Request minor amendment to the approved preliminary / final plat of a minor subdivision adjusting the interior lot line between two existing lots to create two new lots.

PR-2022-006674 / PS-2022-00034 (Sketch); SD-2023-00137 (P/Fplat) ZHE var. VA-2023-00283 thru -00286

Re: Amendment to Preliminary / Final Plat Review for Proposed Lot 16-A and 17-A, Land of Raymond Ortiz

**Plat for  
Lots 16-A and 17-A,  
Land of Raymond Ortiz  
Being Comprised of  
Lots 16 and 17,  
Land of Raymond Ortiz  
City of Albuquerque  
Bernalillo County, New Mexico  
January 2024**

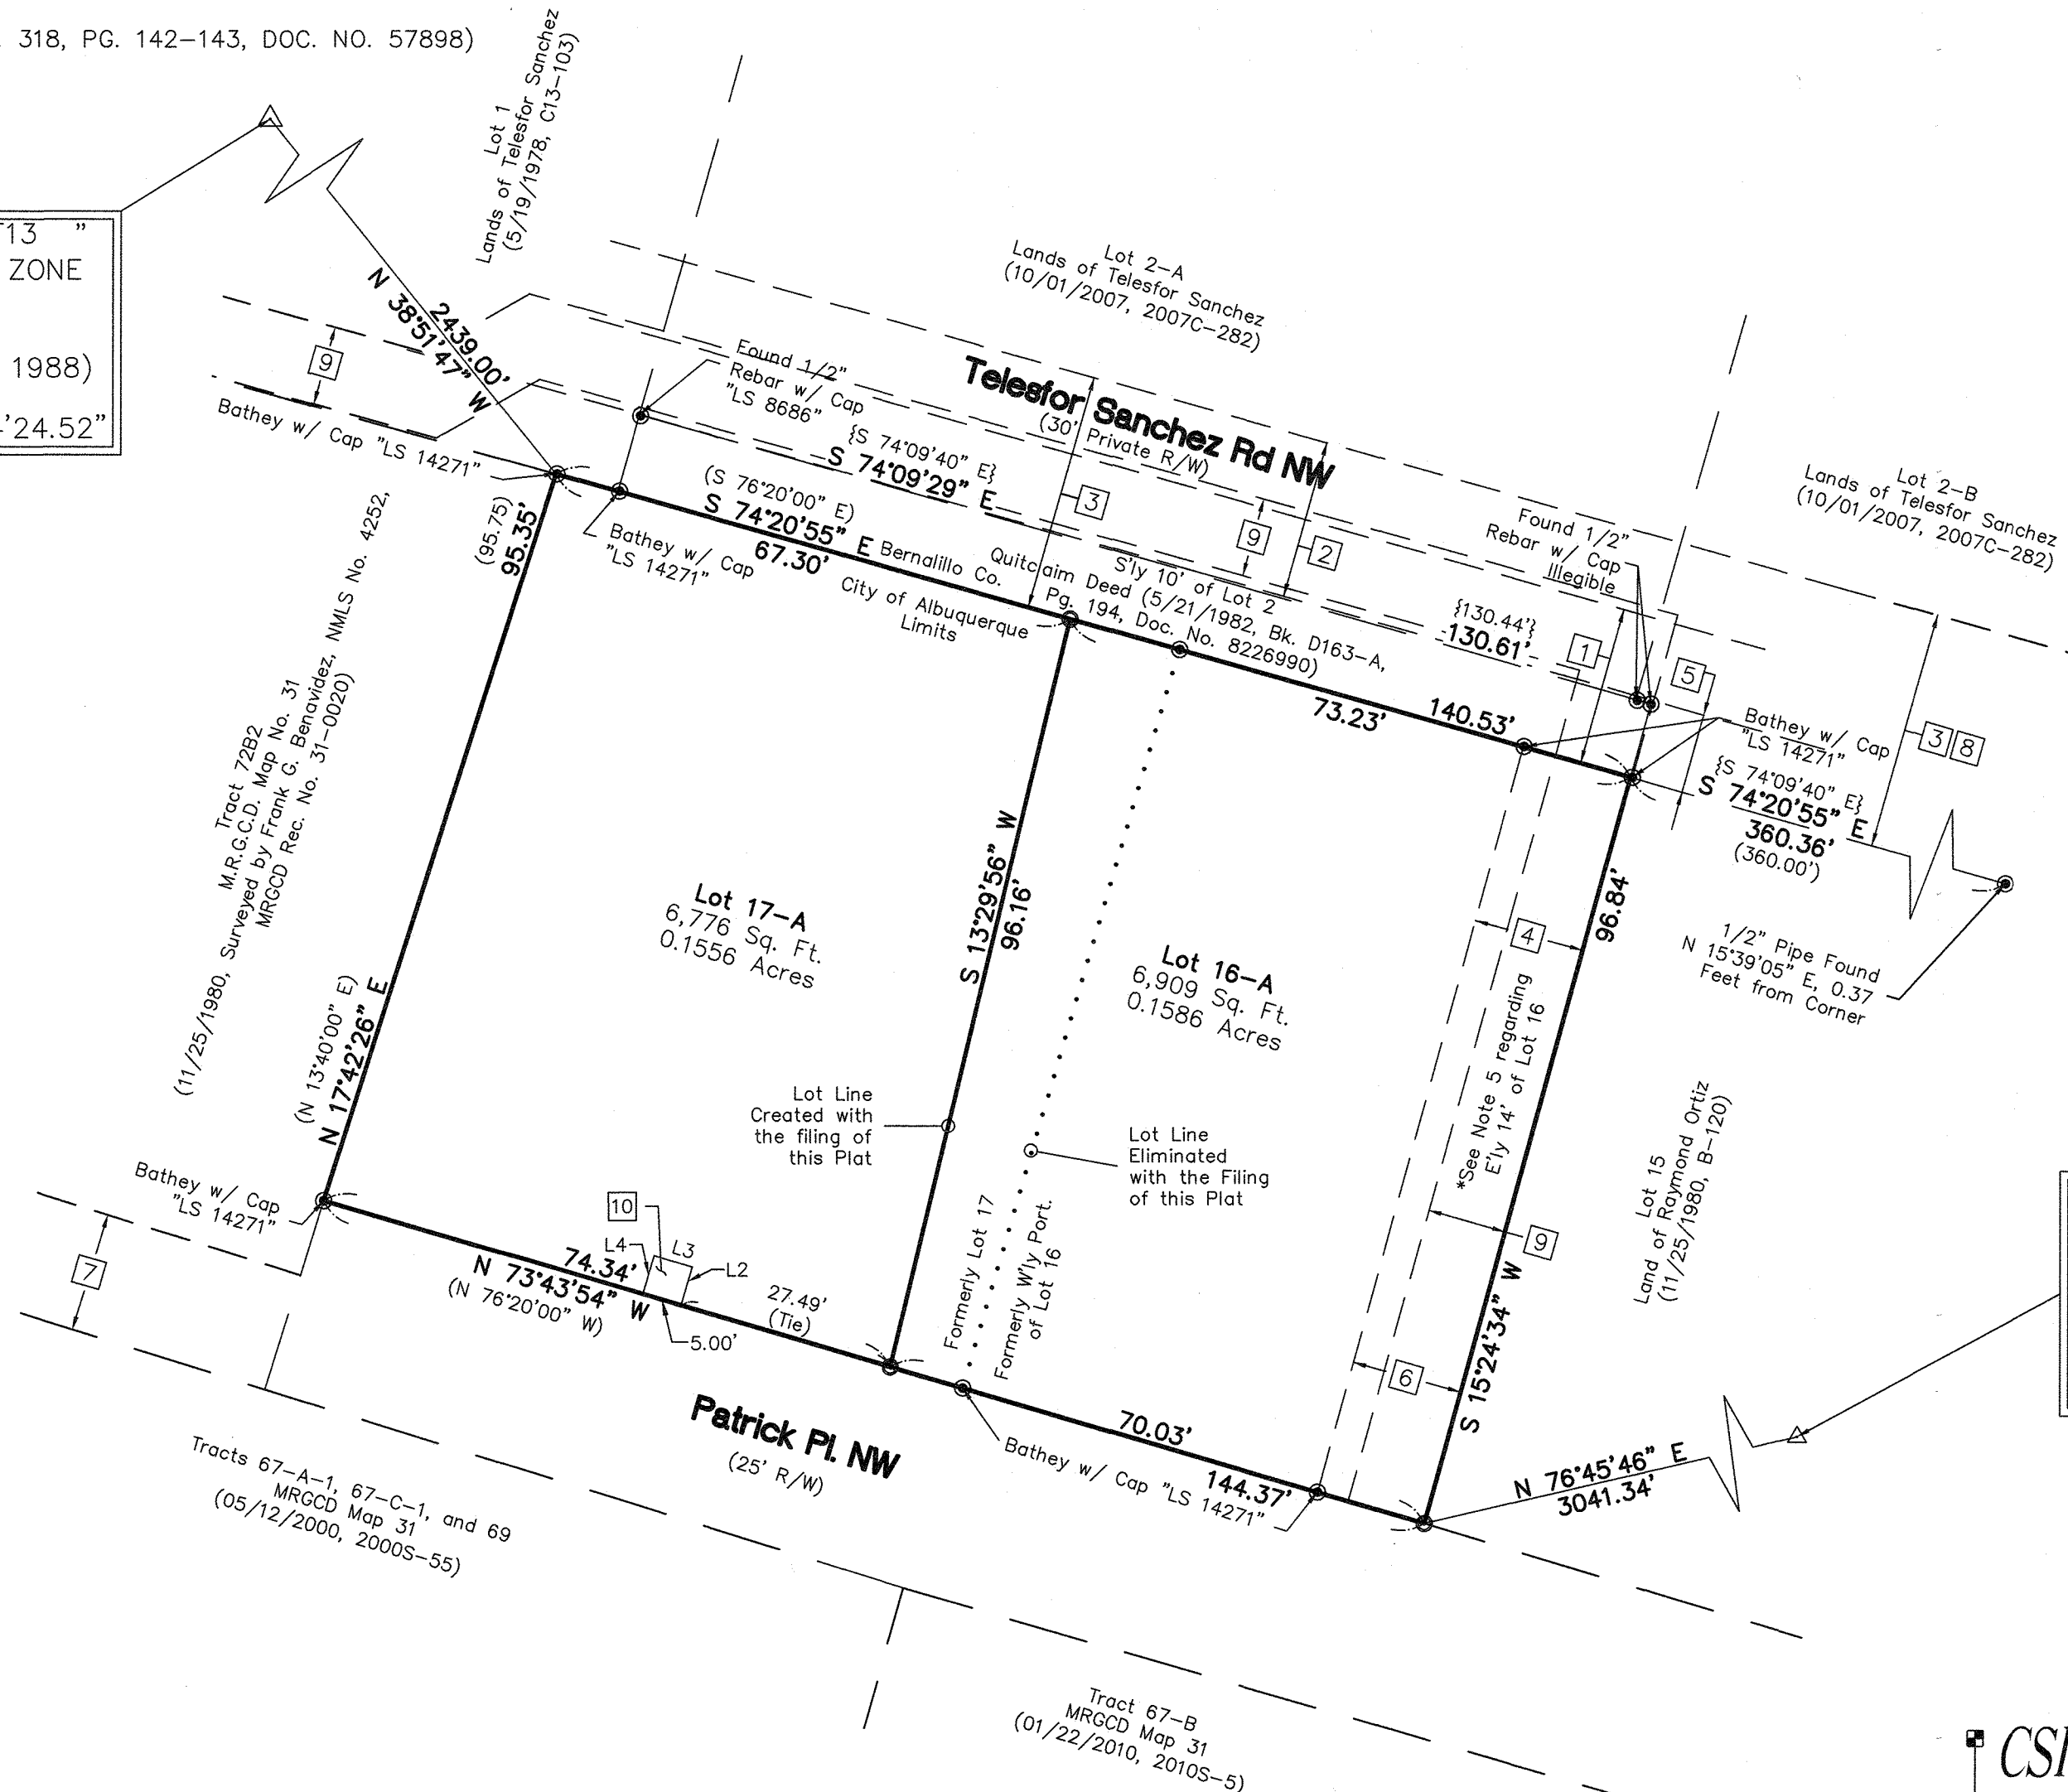
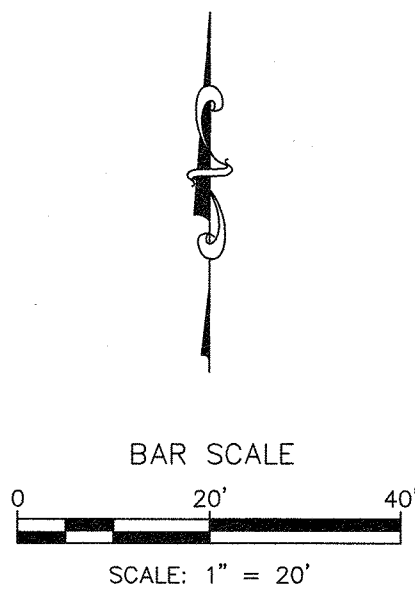
1. Lot 17-A: Lot Width required is 75 ft per Table 5-1-1 for RA-zone.
 - Lot 17-A Deviation of 4.2 feet proposed for width of Lot 17-A is recommended for approval.

3. Lot 17-A Deviation: Request deviation of 0.3 feet of the required 20 feet for the Front Setback of Lot 17-A, recommended for approval.

4. Lot 16-A: Deviation. Requested deviation of 0.9 feet for the West side setback of Lot 16-A. This is not required, as it is covered by Variance VA-2023-00284, allowing a reduction of 1 foot to the 10 ft Side Yard Setback of Lot 16. Deviation note should be removed and replaced with the applicable Variance note.

5. Lot 16-A East side yard setback is deficient, showing 8.4 ft of a required 10 ft setback. However, as this structure appears to be an existing nonconforming structure, the existing non-conforming side setback is allowed to continue under IDO 6-8(D) Nonconforming structures, with the following condition outlined as per IDO 6-8(D)(4), regarding future addition or enlargement:
6-8(D)(4) Setback Nonconformance
A structure nonconforming as to setback regulations cannot be added to or enlarged unless the addition conforms to all the regulations of the zone district in which the structure is located.

1. Patrick Avenue is required to meet minimum right-of-way width requirements (48-foot wide) and roadway width requirements. 5-foot sidewalk is also required along Patrick Avenue.

Noted, we provide justification letters requesting a determination for the Patrick Place Ave right-of-way width.
